**Subject: State Significant Development (SSD 8753) - Concrush Teralba**  
**Lake Macquarie City Council response to Environmental Impact Statement**

Thank you for the opportunity to comment on the Environmental Impact Statement (EIS) for the expansion of the Concrush Resource Recovery Facility, Teralba.

Figure 3: Weighbridge Office and Amenities

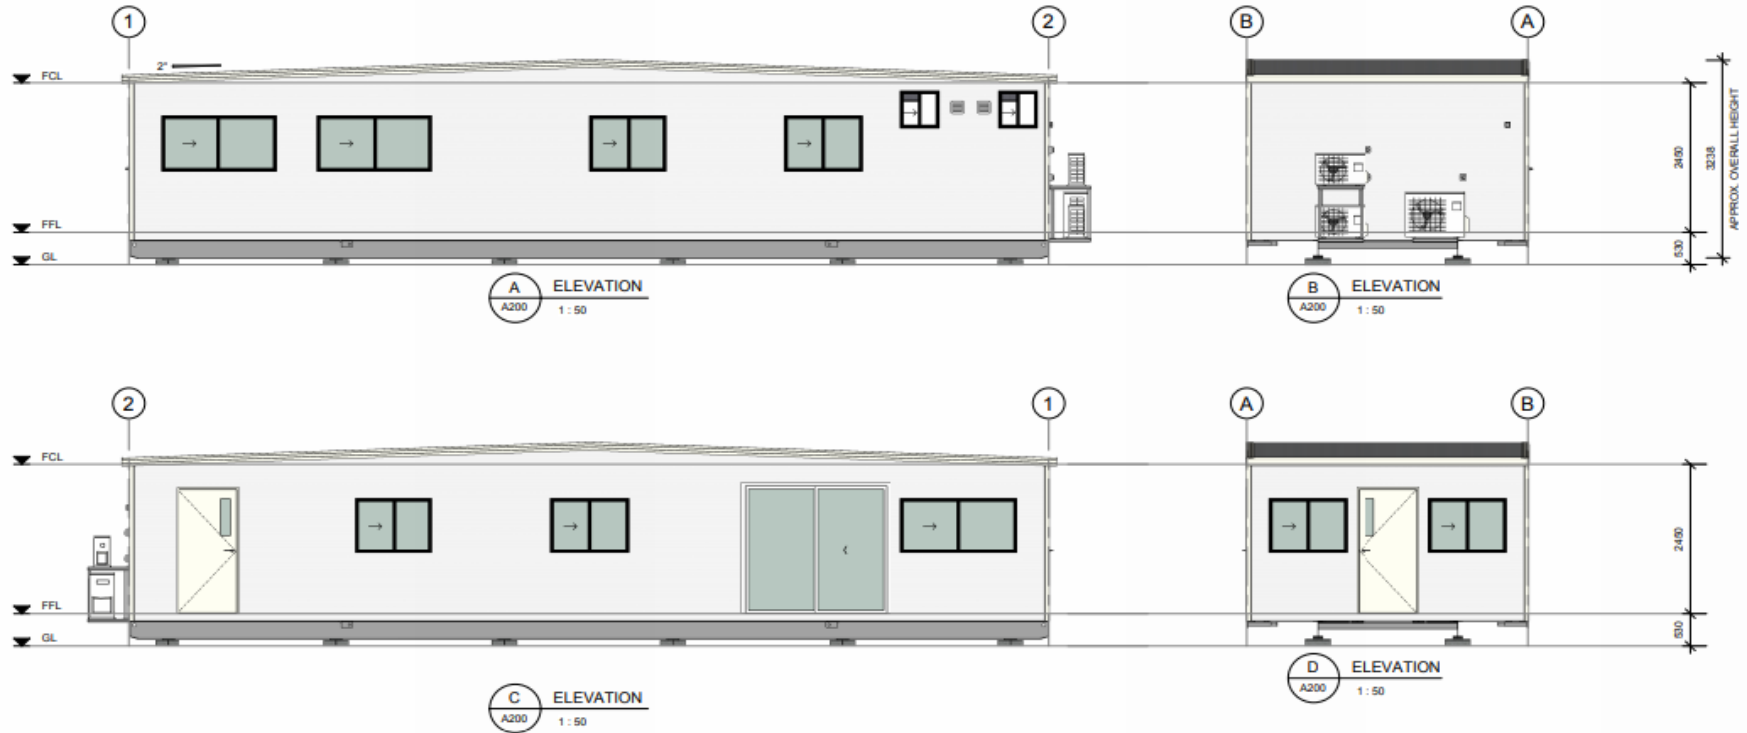
No details have been provided for the proposed maintenance shed and stage 2 weighbridge office / amenities.

Appendix D Building plans do not correlate to any of the identified structures in either stage 1 or 2 with a footprint measurement of 4.4mx14m.

It is suggested that the details of all proposed buildings be provided, and clearly identify their proposed locations. The size of the buildings is particularly relevant to Section 7.11 contributions (see below).
